TRANSPORT ASSESSMENT ADDENDUM

Project:	Land off Ploughley Road, Ambrosden, Oxfordshire – 22/02866/OUT	Page 1 of 6
Subject:	Site Access Arrangements	Date: 10/01/2023

Technical Note Prepared by:	Approved for Issue by:
Christopher Miles Transport Consultant	Max Thurgood Director

© This drawing may not be copied without prior written permission.

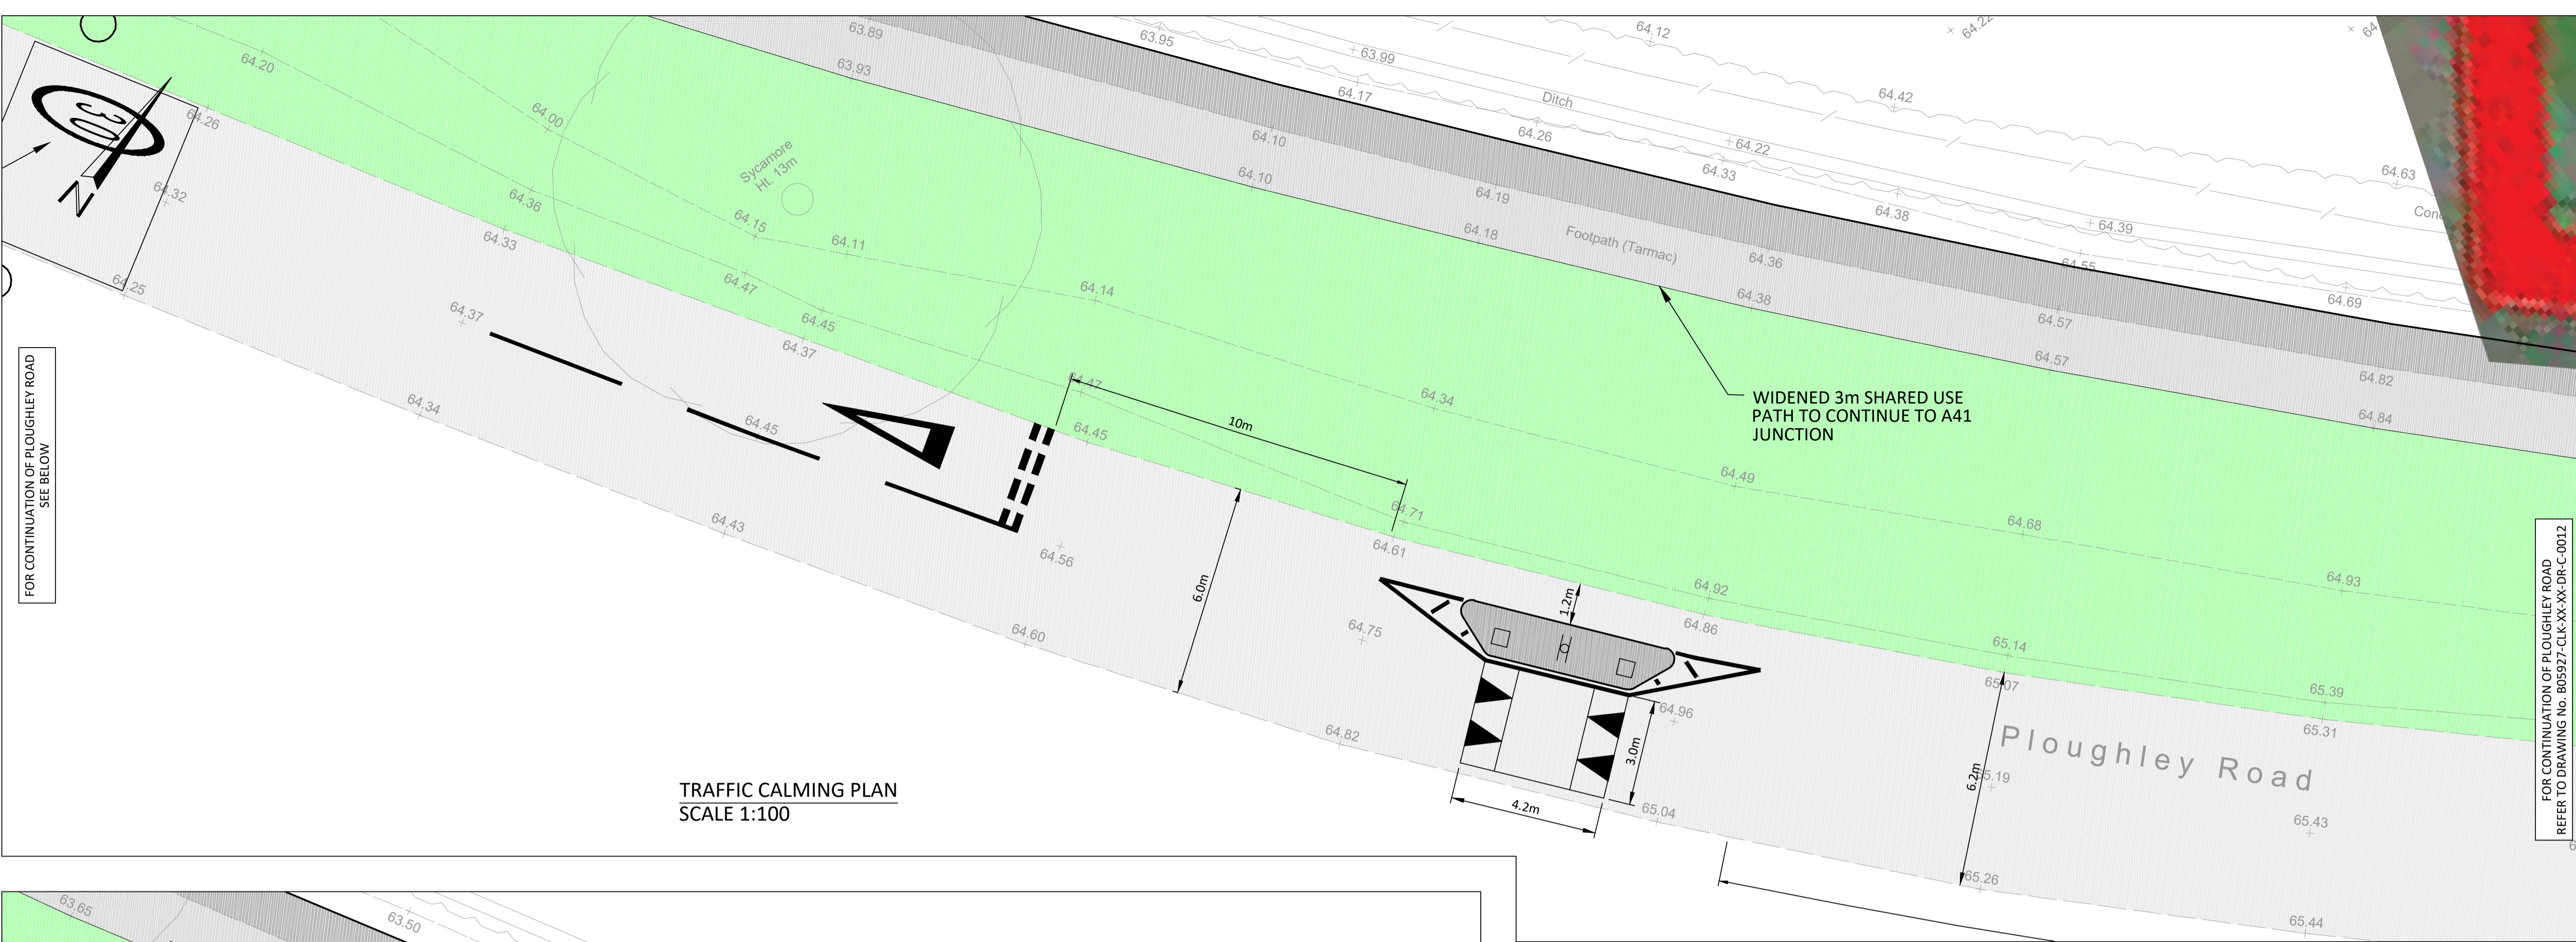
OCC has requested the provision of new bus stops on Ploughley Road in the vicinity of the site frontage. The proposed location and layout of these is shown indicatively on plan 0012_P02 within Appendix B.

The southbound stop would be arranged to provide easy access to the shared use path both to the north and the south with sufficient space available to provide a two-bay shelter, pole with flag and timetable casement. A drop kerb crossing point would also be incorporated to enable convenient pedestrian movements over Ploughley Road to and from the northbound stop.

Topographical survey information of the western verge is not currently available, but it would appear from site observations and the extent of the adopted highway (attached as **Appendix C**) that a two-bay shelter, pole with flag and timetable casement can also be provided within the western verge. This would cater for northbound services.

VEHICLE TRACK  
SCALE 1:200

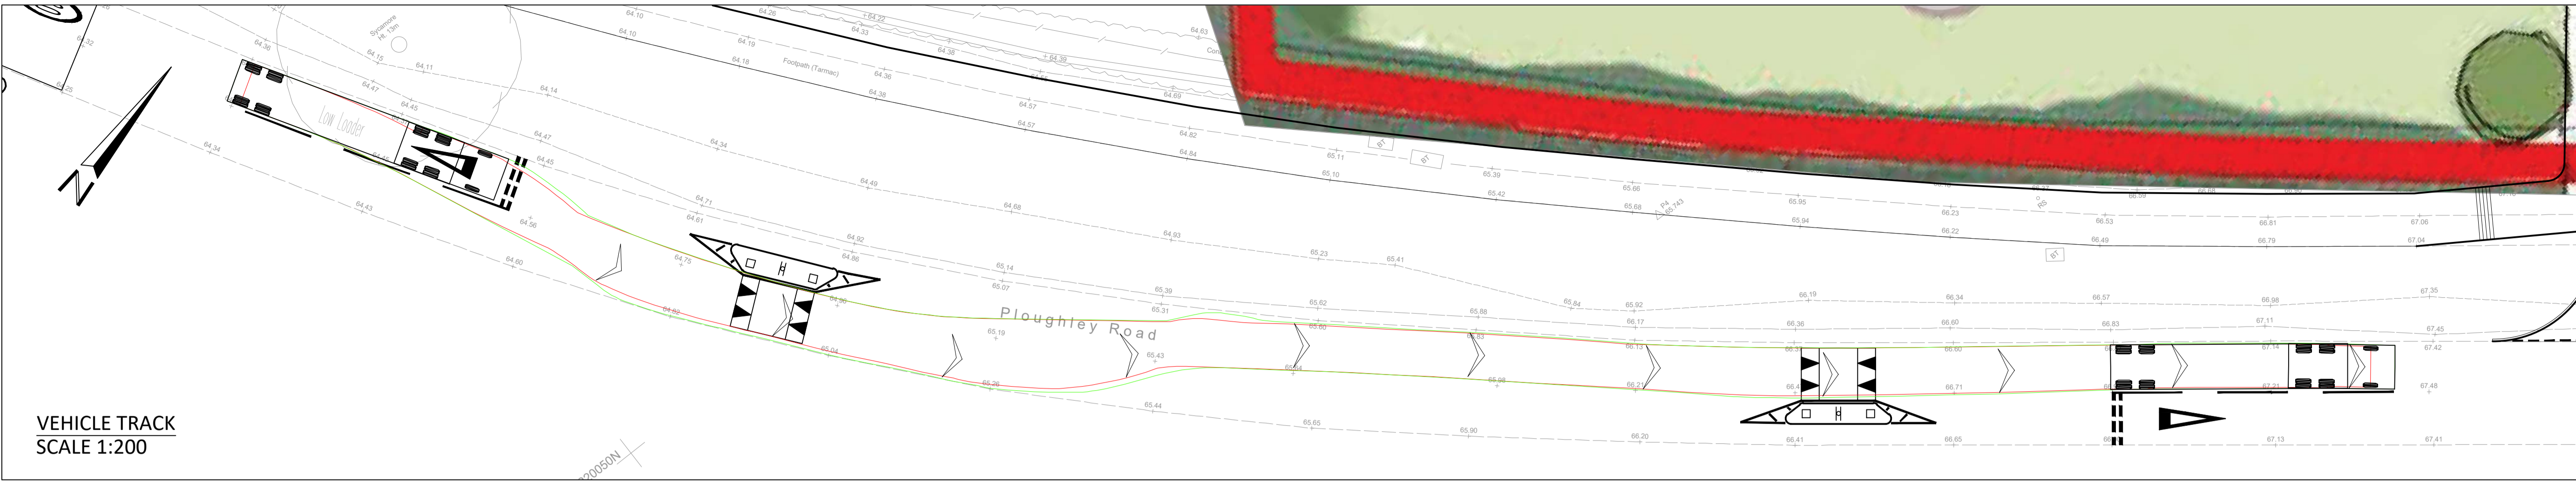
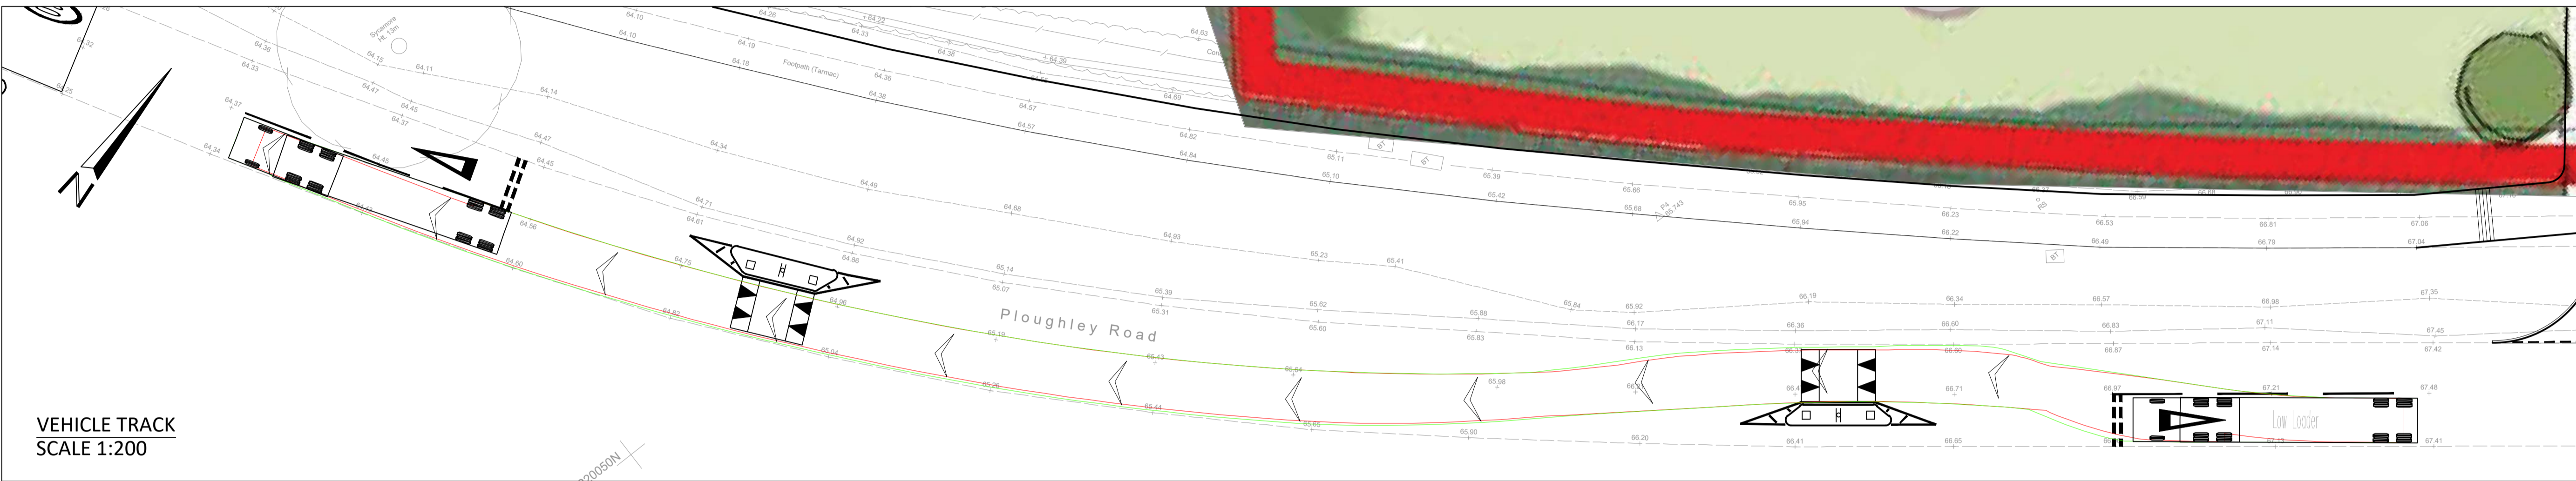
It is acknowledged that there is a large military presence in the local area including Bicester Garrison within Ambrosden itself. The traffic calming feature has therefore been positioned to ensure that a large articulated low loader vehicle can pass through the feature in both directions without undue difficulty, as shown by the swept path analysis.
